## **Silvertown Tunnel Development Consent Order**

### **Written Representations**

### **The Royal Borough of Greenwich**

15<sup>th</sup> November 2016

Figure 2-3 A102 Northbound Environmental Barrier Location Plan

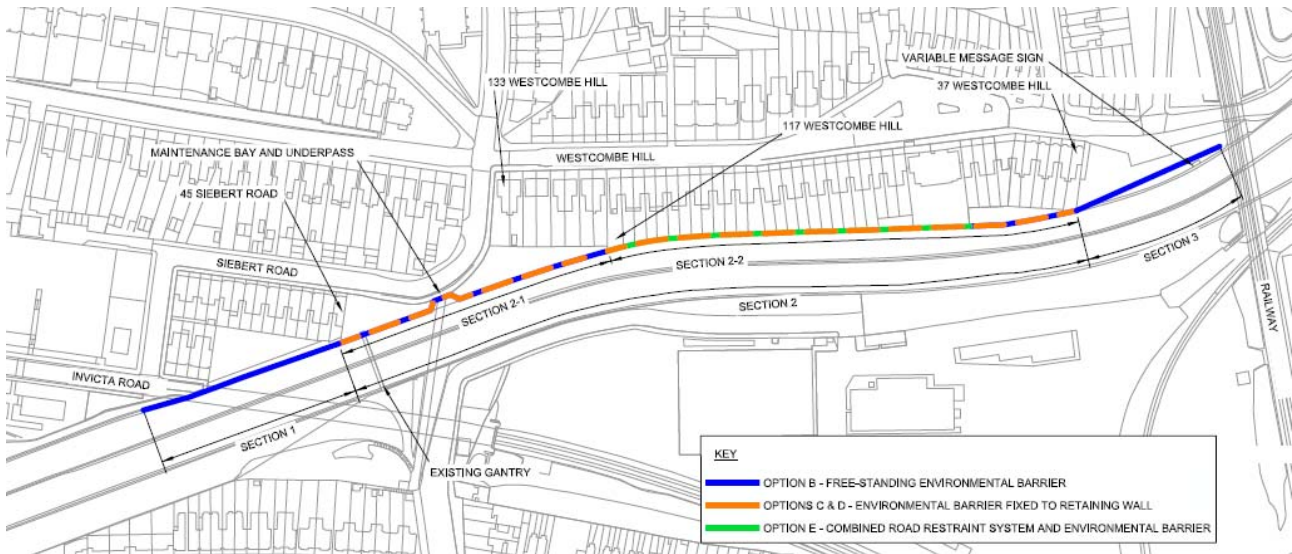
- 5.7 Seibert Road is directly adjacent to the A102’s northbound carriageway. Currently there is no noise mitigation for residents. When free flow conditions are experienced road noise levels are at their highest. The Scheme will (according to TfL’s models) allow these conditions to be experienced more often and therefore noise levels will potentially be higher. TfL have agreed to fund the implementation of noise barriers if the Scheme is approved as part of a separate legal agreement. RBG would wish this included as a Requirement<sup>11</sup>.

Figure A1: Assessed Case indicative bus network

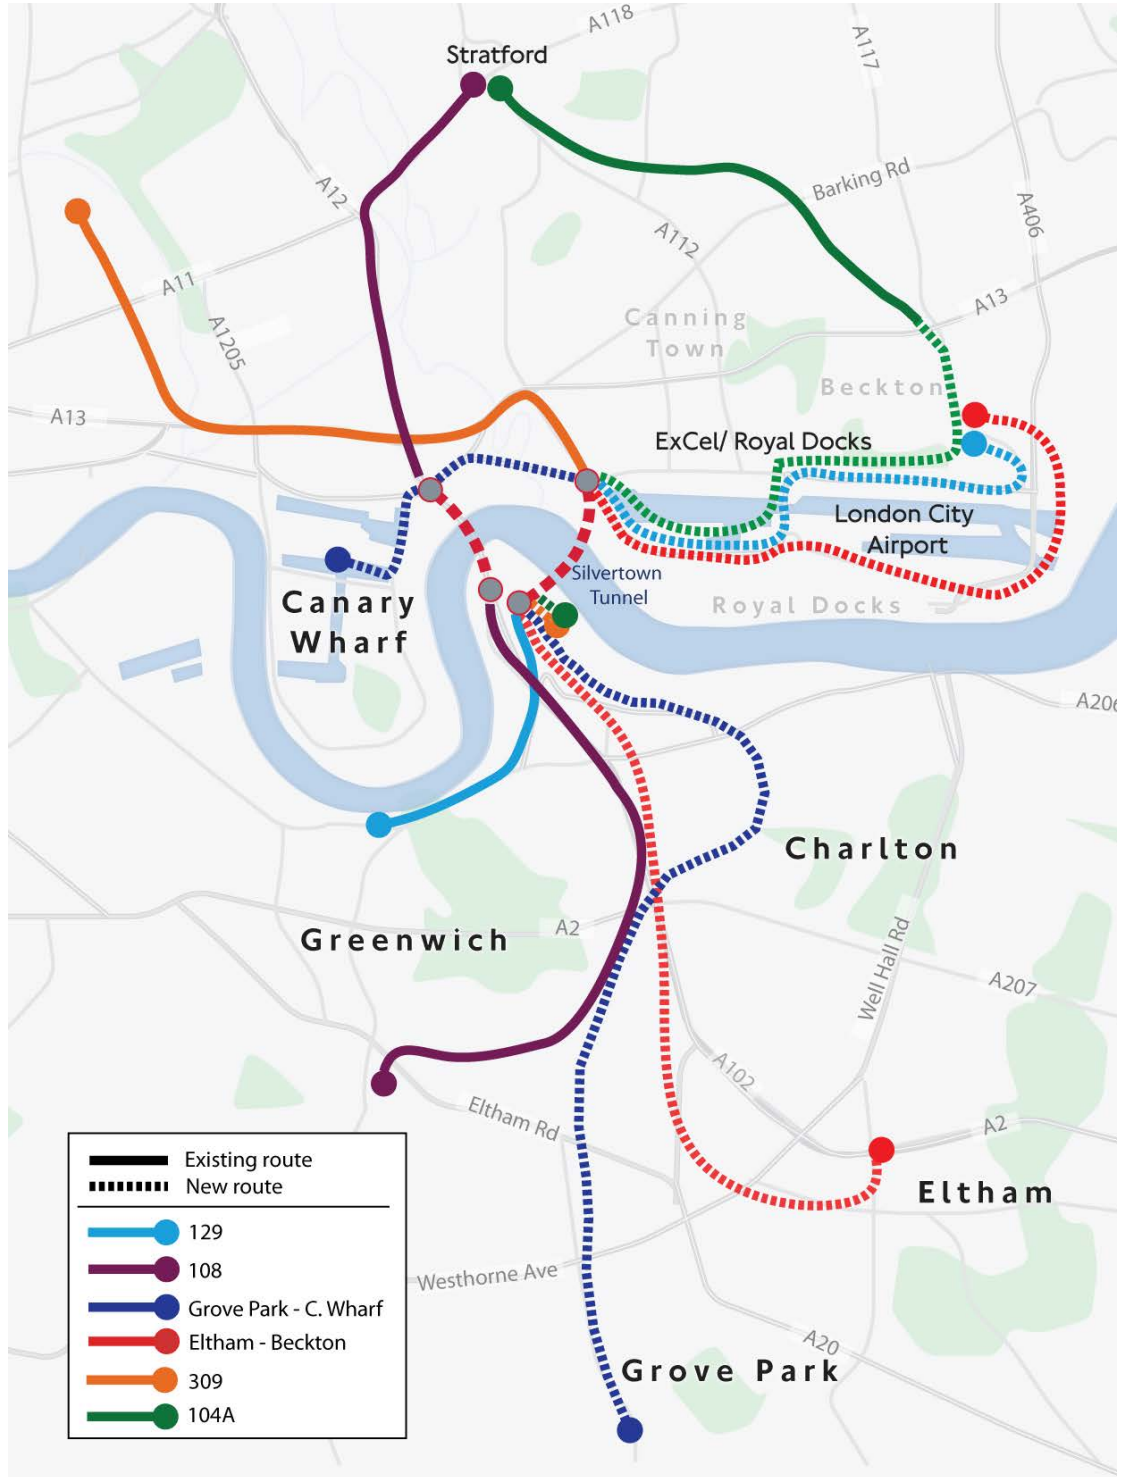
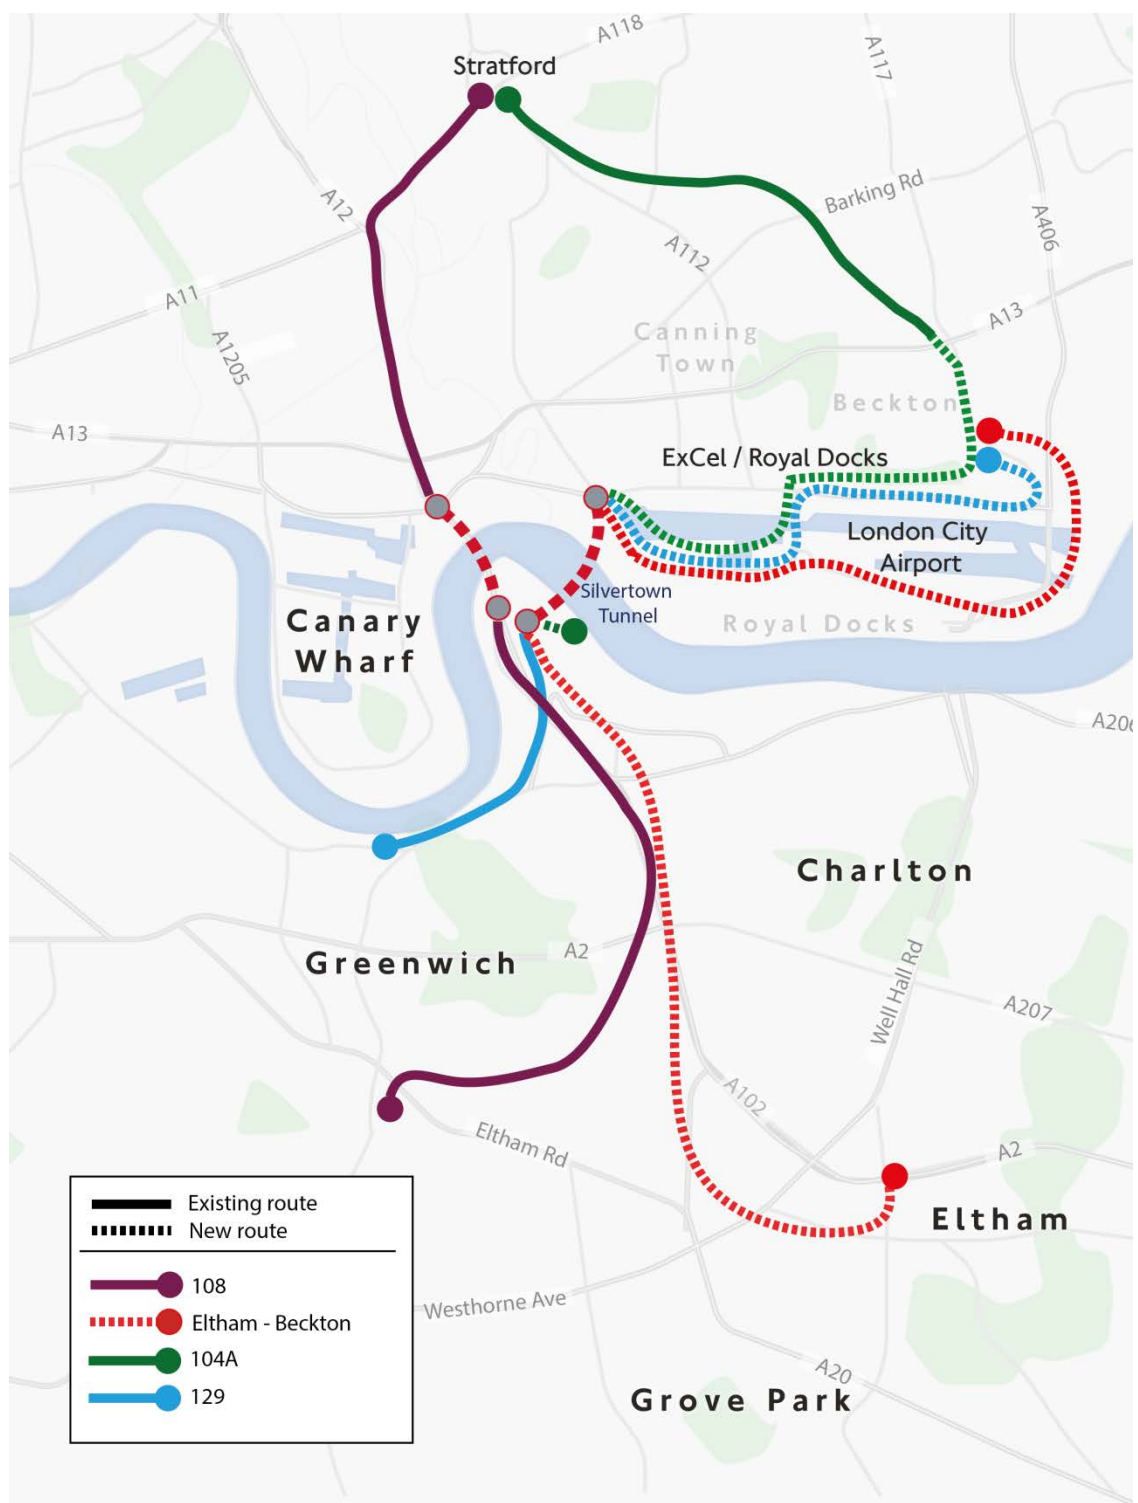
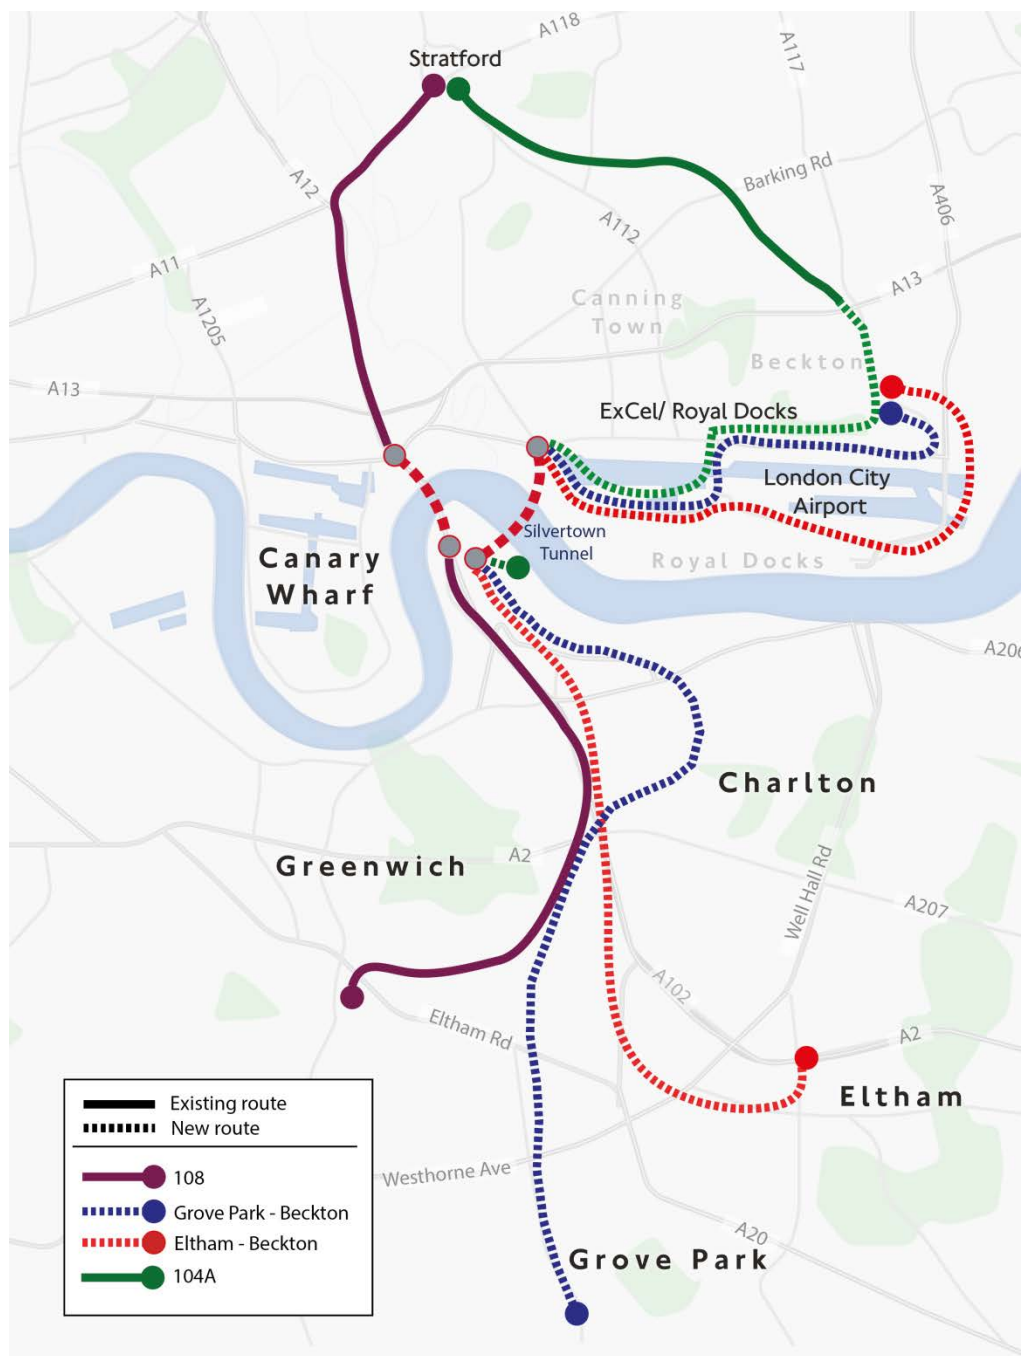
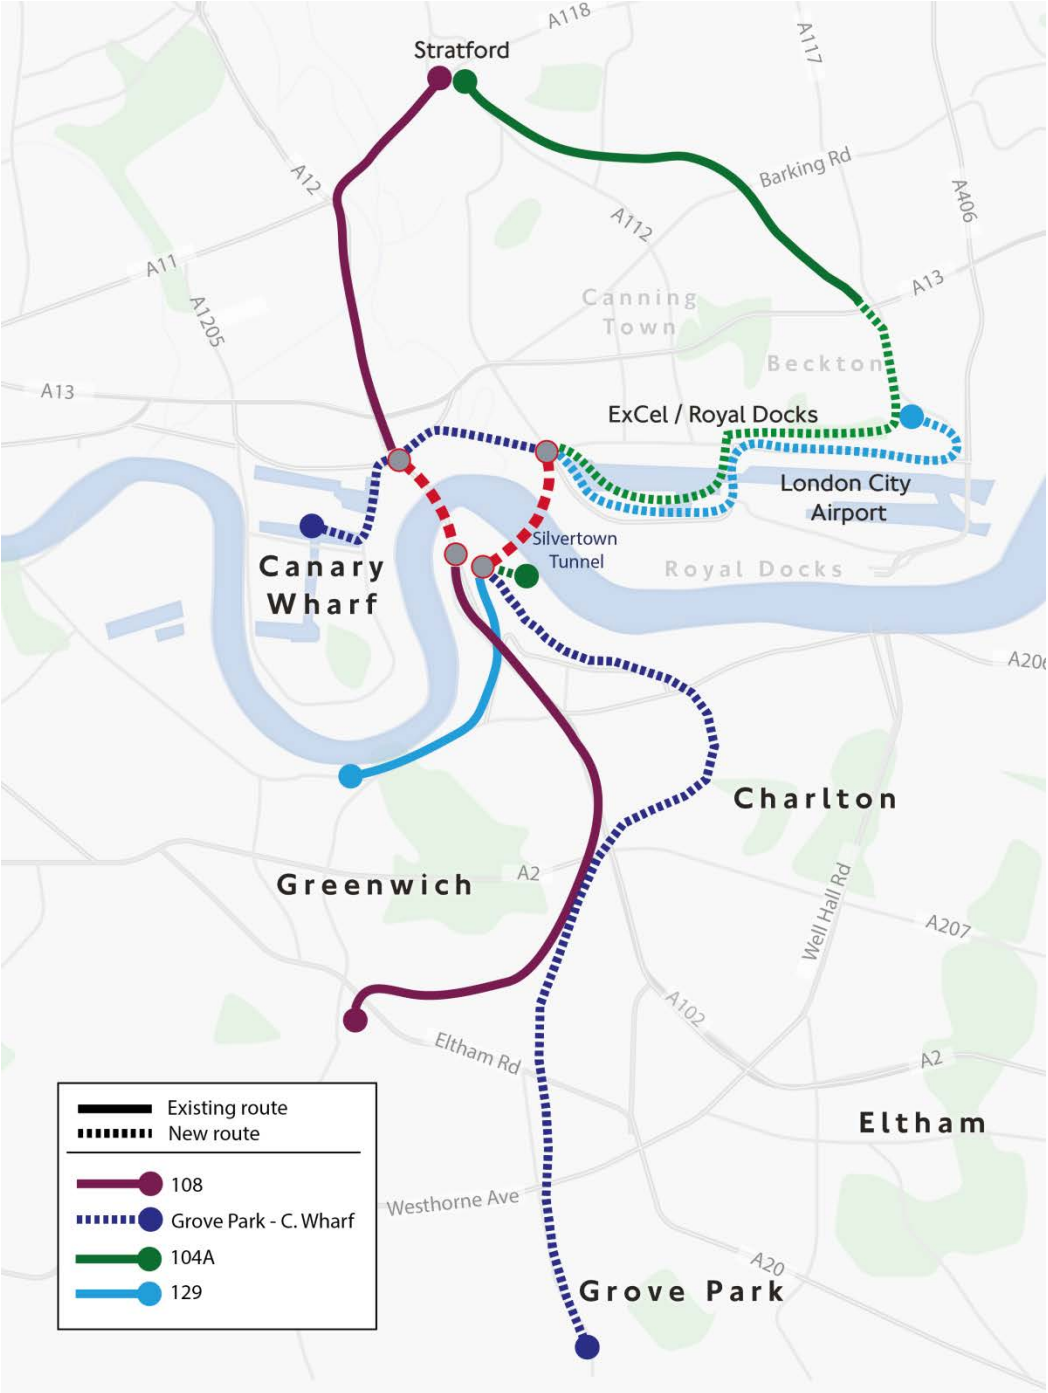
- 3.3 Notwithstanding the Mayor of London's recent announcement (that they would form part of the next TfL Business Plan) the modelled bus routes in the Assessed Case are not, as yet, secured through the DCO. RBG takes the view that these should be included in the DCO in the form of a Requirement for a Bus Strategy to be produced by TfL and approved by the Host Boroughs prior to the Scheme's opening.

- 9.4 The proposed bus network which is shown in the documents and which has been used as part of the traffic model for the assessed case is not committed or funded by the DCO<sup>22</sup>. The Mayor's announcement that this would form part of TfL's 2016 Business Plan is welcomed, however until that is defined and secured it should not be assumed as a deliverable.
